Our reference: SF/16/38066
DOC17/301826

Proposed Lead Acid Battery Recycling Facility at 10 Lancaster Street, Ingleburn NSW

The EPA's Air Technical Advisory Services Unit (ATASU) has reviewed the Response to EPA Submissions on air quality (Wilkinson Murray, 2017a)¹ and the revised Air Quality Impact Assessment (Wilkinson Murray, 2017b)² (the Assessment). The EPA has referred to the Approved Methods for Modelling and Assessment of Air Pollutants 2005 (as the proposal was submitted prior to 2017) for the purposes of the review.

**Figure 7-1 Source Location**

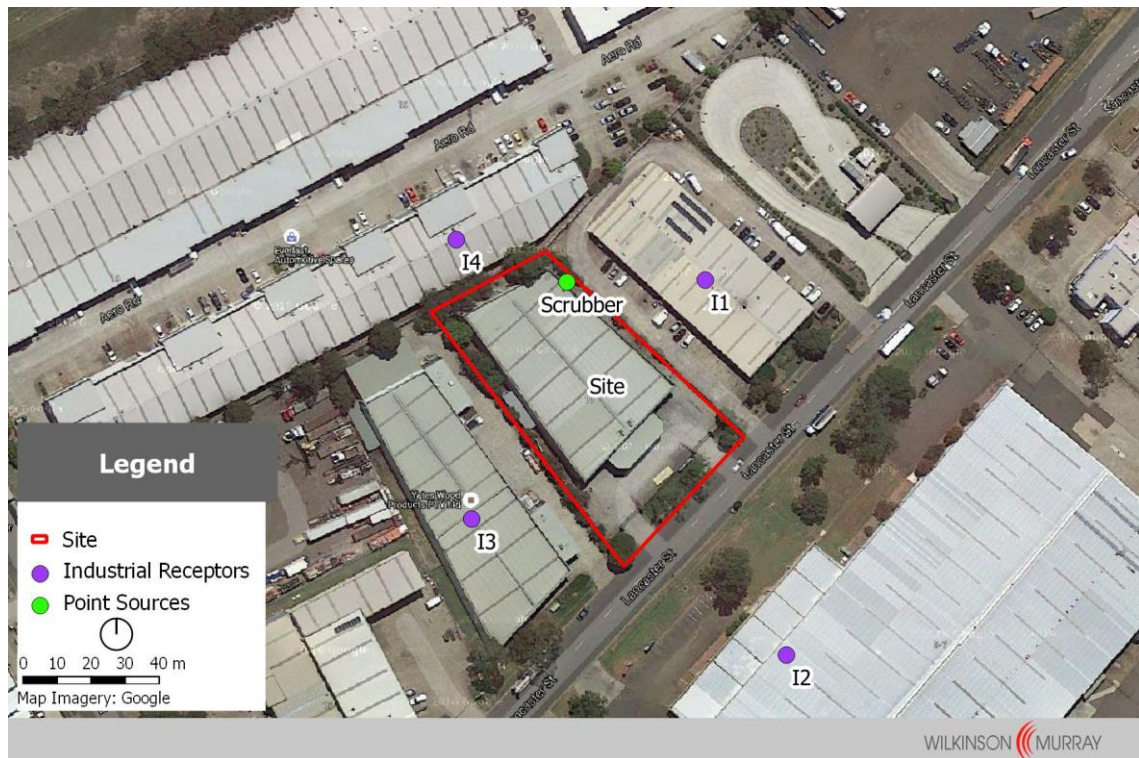
The EPA notes that the Assessment states that “the emissions specification is based on the incorporation of a wet scrubber at the minimum extraction efficiencies of 92% and 60% for lead and particulate matter”. The EPA advise that emission controls should be able to achieve a minimum control efficiency of 90% for particulate matter, in line with contemporary emission performances.

The EPA recommends that the proponent provide additional information to demonstrate that the wet scrubber will achieve a control efficiency that is representative of contemporary emission control performances.
